Application for Planning Permission for Works or Extension to a Dwelling

Development Removal of tiled mansard to first floor, replacement of existing two-storey glazed front entrance, new front dormer with rooflight, alterations to existing rear dormer & balcony, new external staircase to rear, alterations to external fenestration, new boundary walls with gates & railings to front elevation

Location 1 Botany Close Rustington

I regret that I am unable to accept your documents as a formal application until the following matters have been resolved :-

14.02.12	1: 100 @ A3	0293(00)06	-

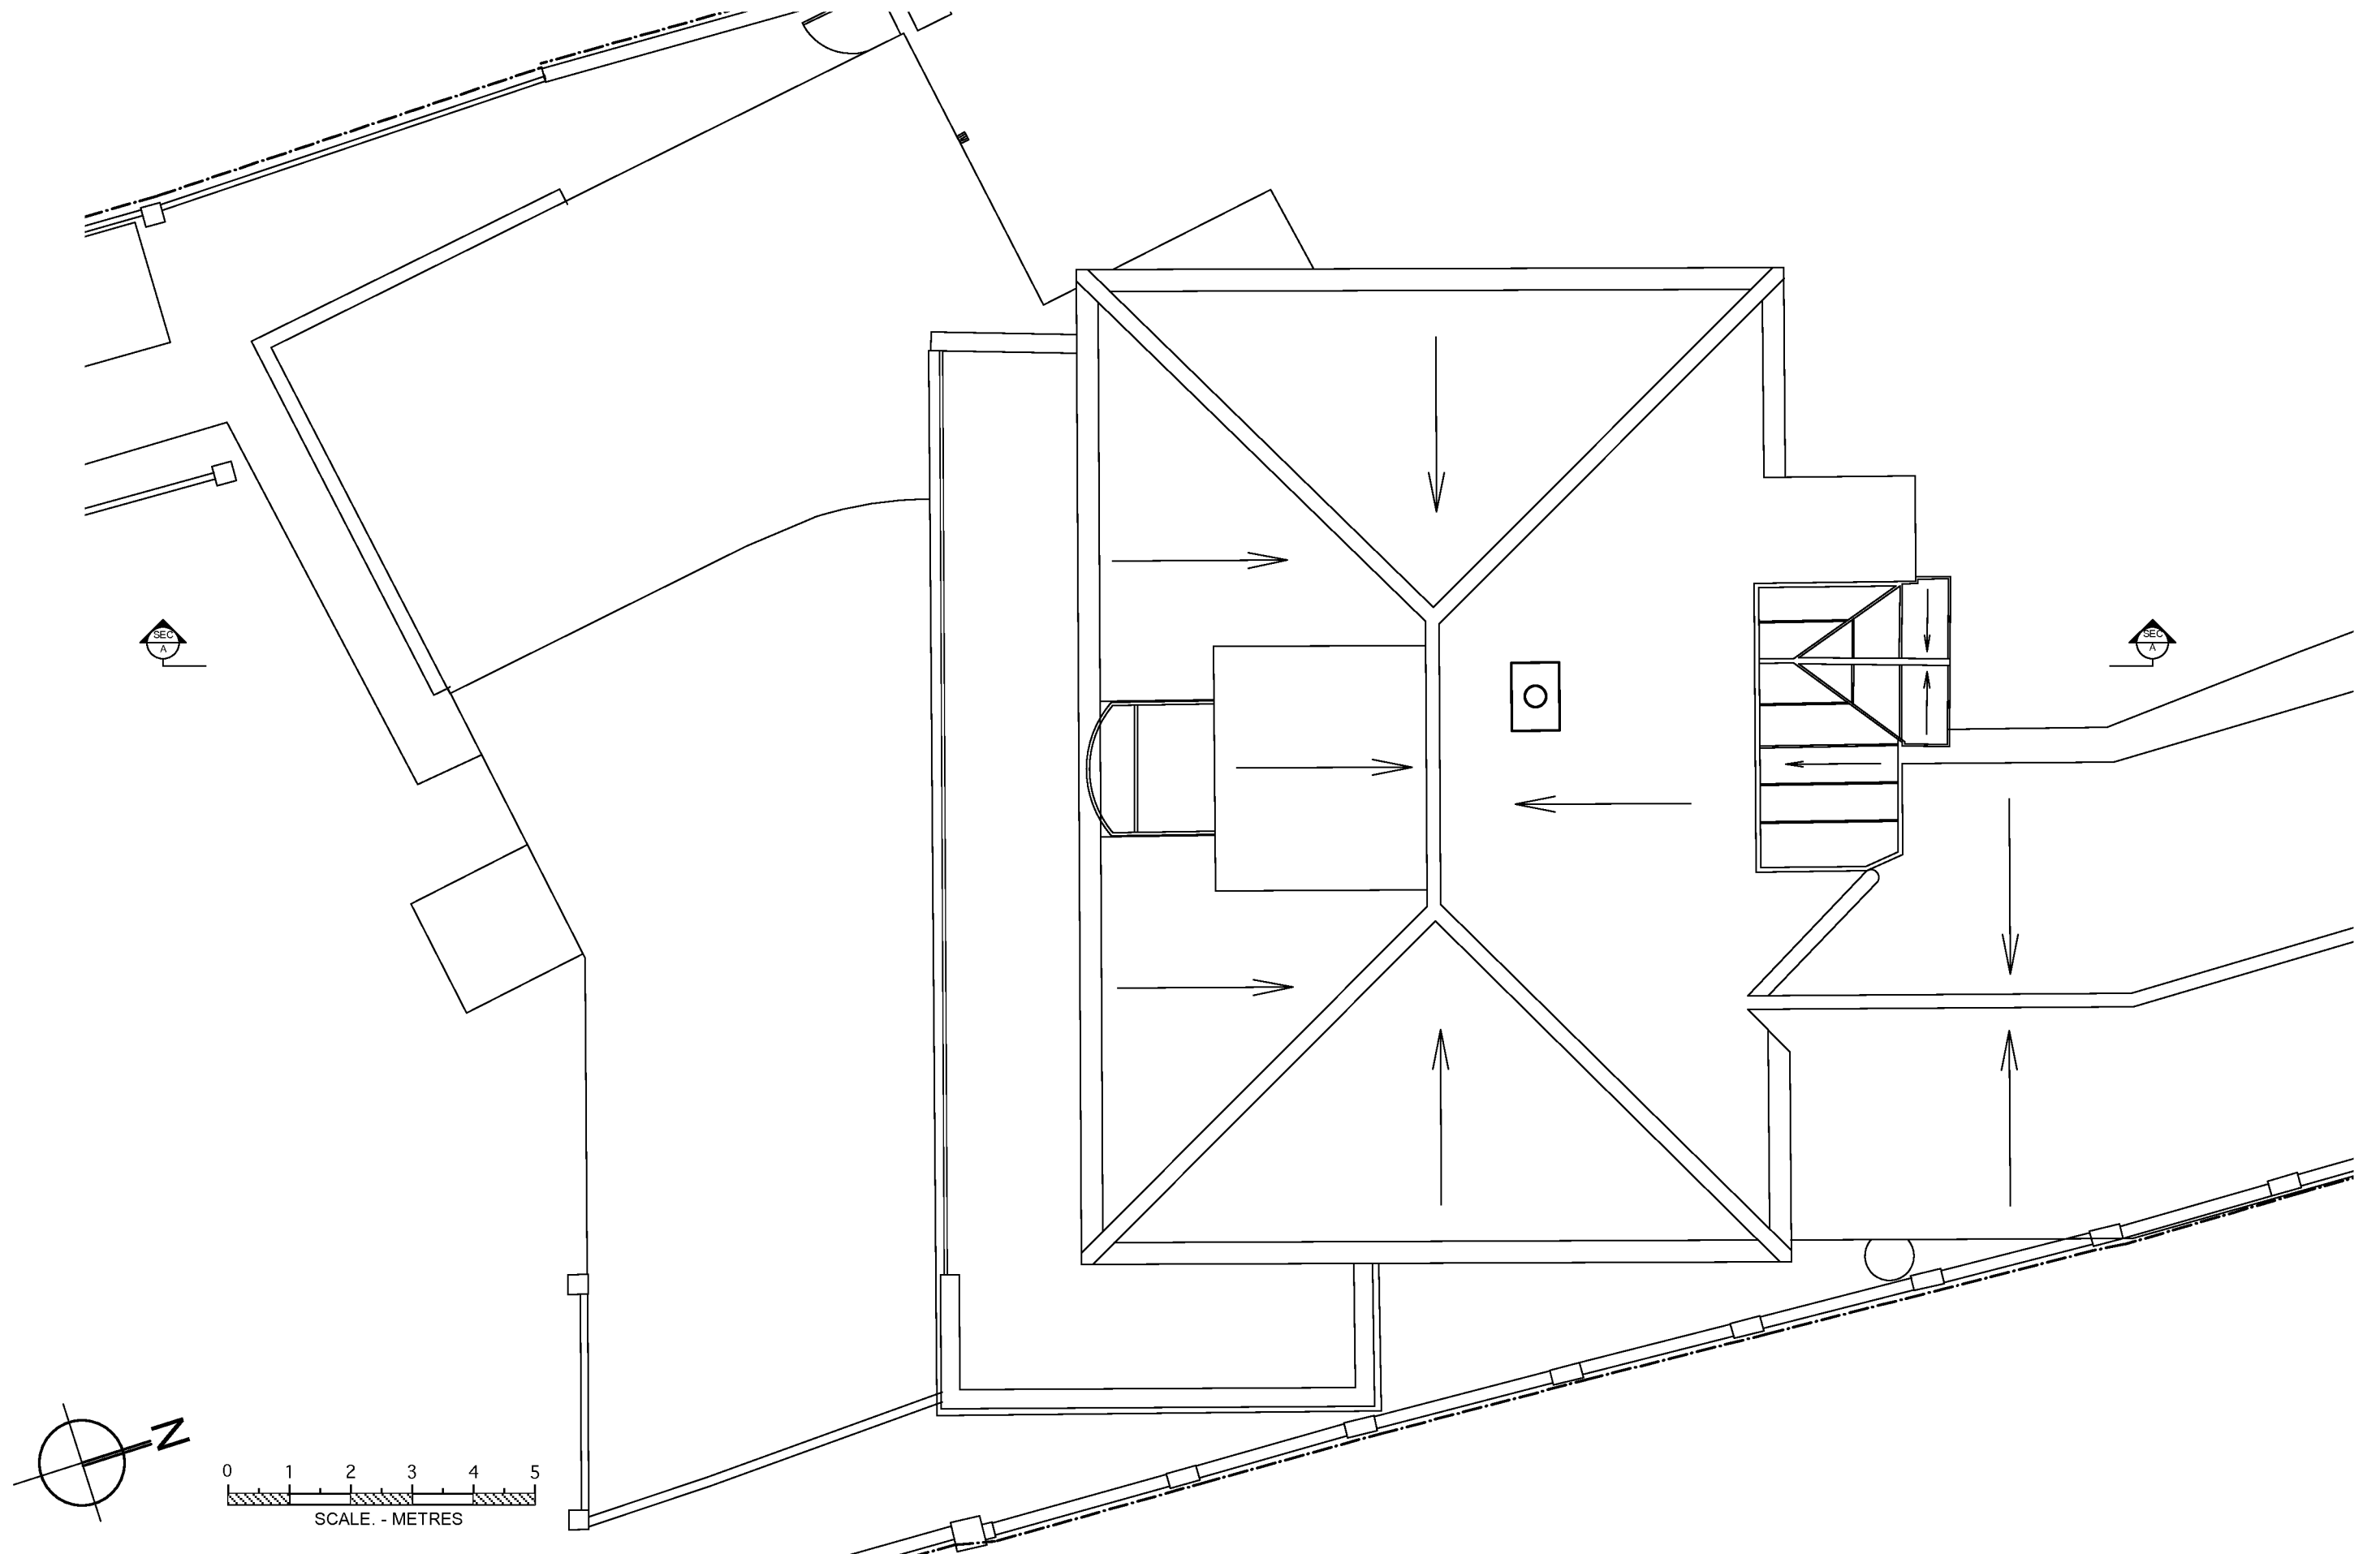
Please provide 1 electronic or 3 paper copies of revised existing and proposed elevations:

- The garage shown on the floor plans does not accord with front elevations. Please provide the following amended plans: existing and proposed front elevations (0293(00)06 (street view), 0293(00)07, 0293(01)06 Rev E (street view), 0293(01)07 Rev C and 0293(01)14).
- The existing and proposed east and west elevations have been labelled incorrectly (the east elevations correspond with the west side of the floor plans and vice versa). Please provide amended plans (0293(00)11, 0293(00)10, 0293(01)11 Rev B and 0293(01)10 Rev C).
